City of Portland, Maine - Building or Use Permit Application

Job No: 2011-12-2859-ALTR	Date Applied: 12/5/2011	CBL: 064- A-012-001	
Location of Construction: 212 ST JOHN ST	Owner Name: TIM Q LY	Owner Address: 212 ST JOHN ST PORTLAND, ME 04102	Phone: 207-650-6932
Business Name:	Contractor Name: Owner	Contractor Address:	Phone:
Lessee/Buyer's Name:	Phone:	Permit Type: BLDG - Building	Zone: B-2
Past Use: Two family	Proposed Use: Same - Two family - replace 4 egress windows	Cost of Work: 1000.00	CEO District:
		Fire Dept: <input type="checkbox"/> Approved <input type="checkbox"/> Denied <input type="checkbox"/> N/A	Inspection: Use Group: R3 Type: SR MUREC Signature: 
Proposed Project Description: 4 BR egress windows Per Previous Permit 040110		Pedestrian Activities District (P.A.D.)

has permission to Replace four (4) existing bedroom egress windows per previous permit # 040110.
provided that the person or persons, firm or corporation accepting this permit shall comply with all of the provisions of the Statues of Maine and of the Ordinances of the City of Portland regulating the construction, maintenance and use of the buildings and structures, and of the application on file in the de

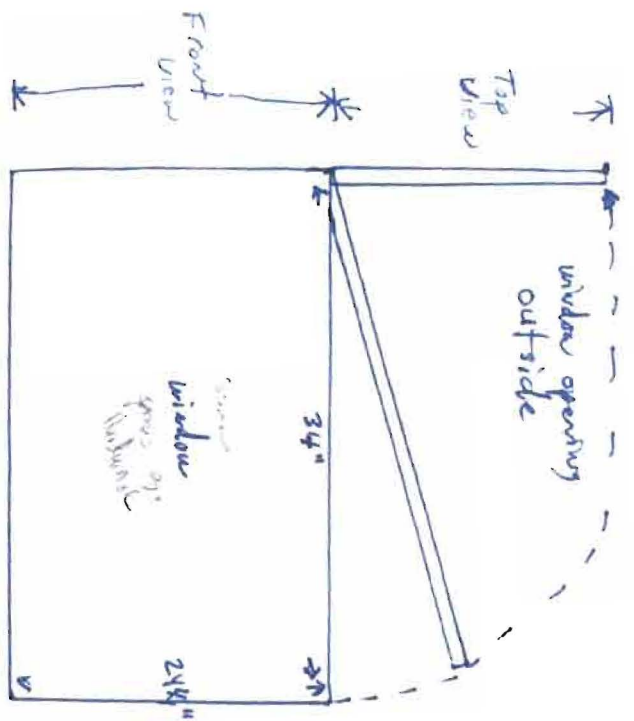
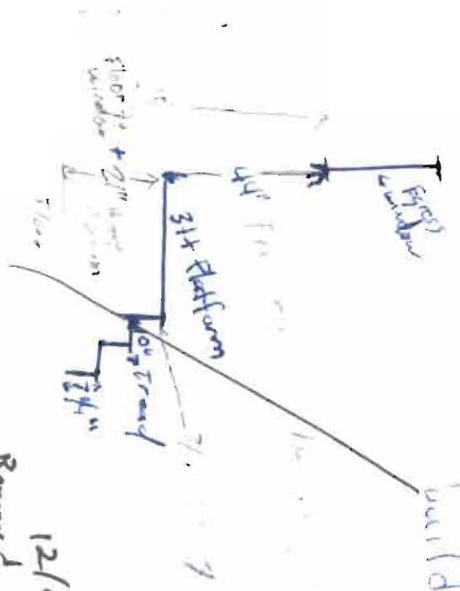
6. A code compliant emergency escape shall be provided in the bedroom. Window sills in locations more than 72 inches from finished grade shall be a minimum of 24 inches (no higher than 44 inches) above the finished floor of the room, or in compliance with Section R612.4.2 Operation for emergency escape.

7. **Note: Header and Girder spans for each window must comply with Table R502.5(1) if new framing is required. A Close-In inspection will verify if modifications are required. Met with Owner he will create a window well for both basement casement windows; and remove the proposed egress window steps in the basement. See attachment for for code specifications.**
